From: Mel Hargreaves [REDACTED]
Sent: 25 February 2026 13:15
To: Hebe Smith <Hebe.Smith@arun.gov.uk>
Subject: Re: Application FG/6/26/PL - Little Twittens Recreation Ground

I am the case officer for your application at the address above. I notice in the document submitted from NottSport ref: AN25-167/FERR250902, there is reference to a net. Please could you confirm if any permanent net is to be erected on or around the wicket?

Pre development
Plan
Baseline Map

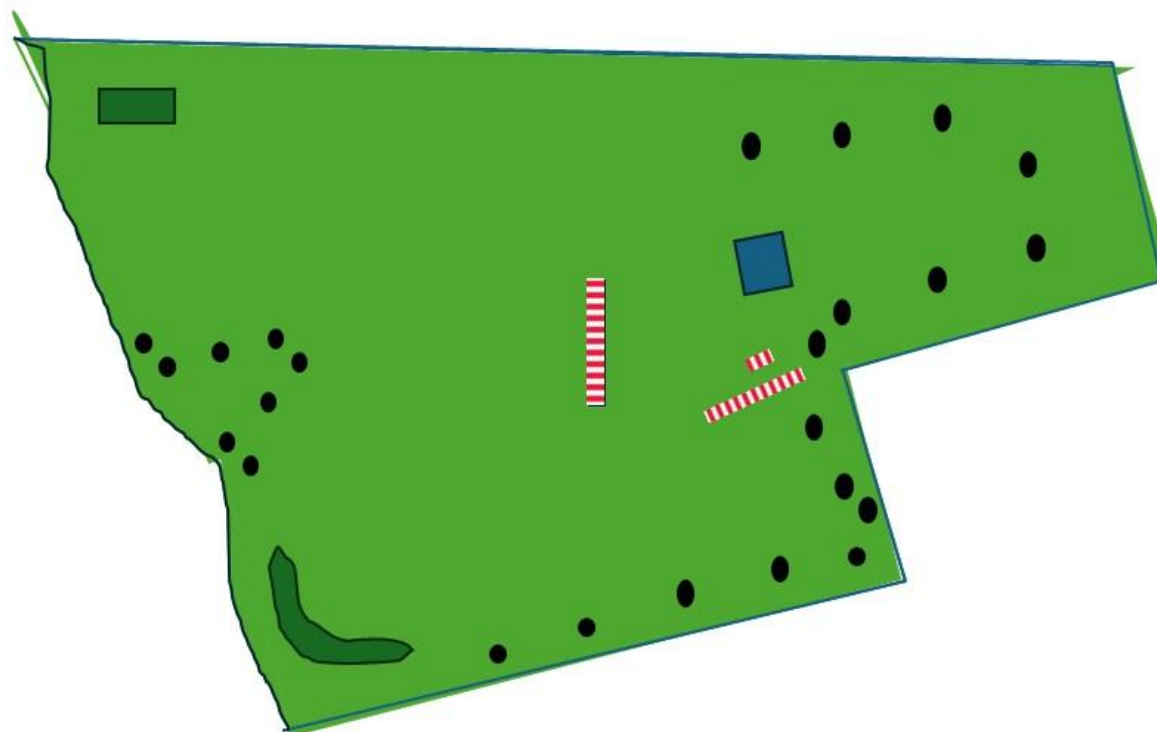
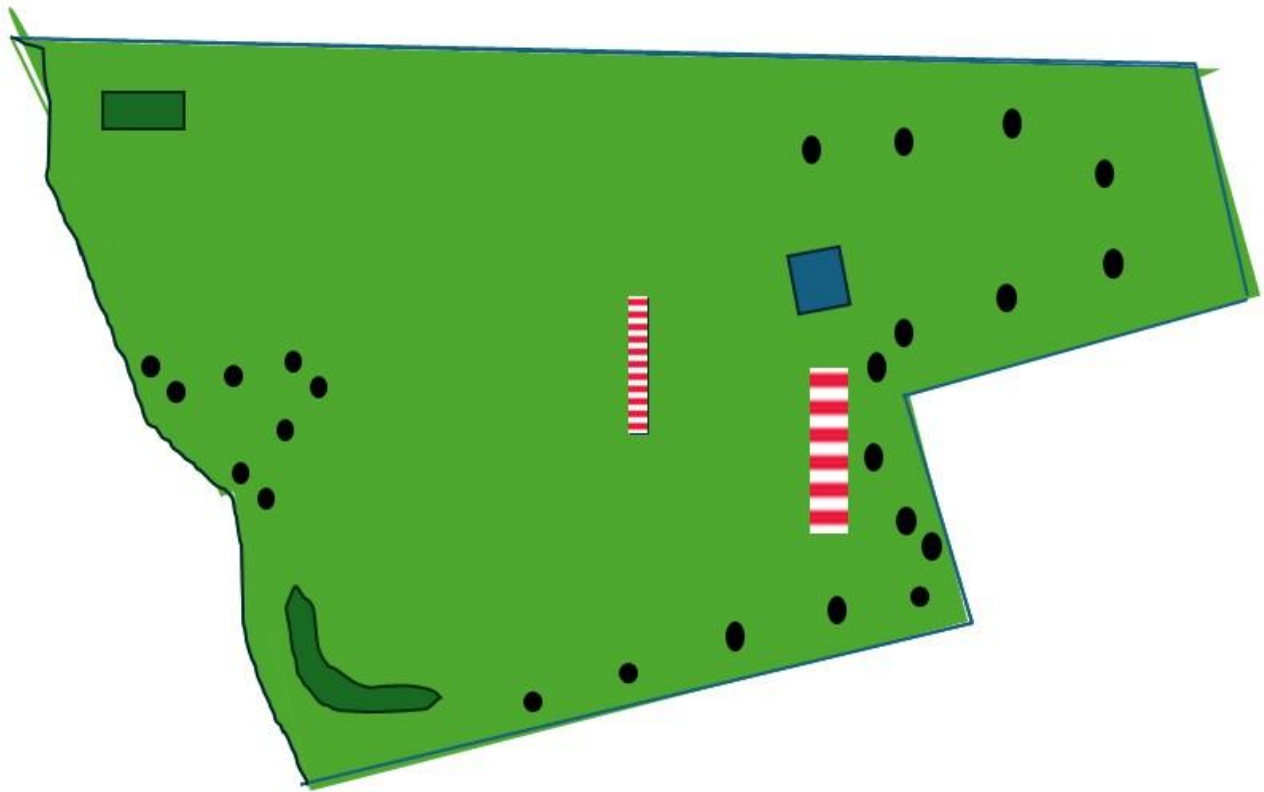
In addition, I have now heard from the council's ecologist, and his response is attached. Whilst there is no objection to the proposed BNG measures, it would be helpful to see where the proposed grassland modification will take place within the site, and how you propose to create the habitat specified. It may be useful for you to consider this, to avoid problems or delays in discharging the BNG condition which will be attached to the permission.

Noted with regarding the habitat.
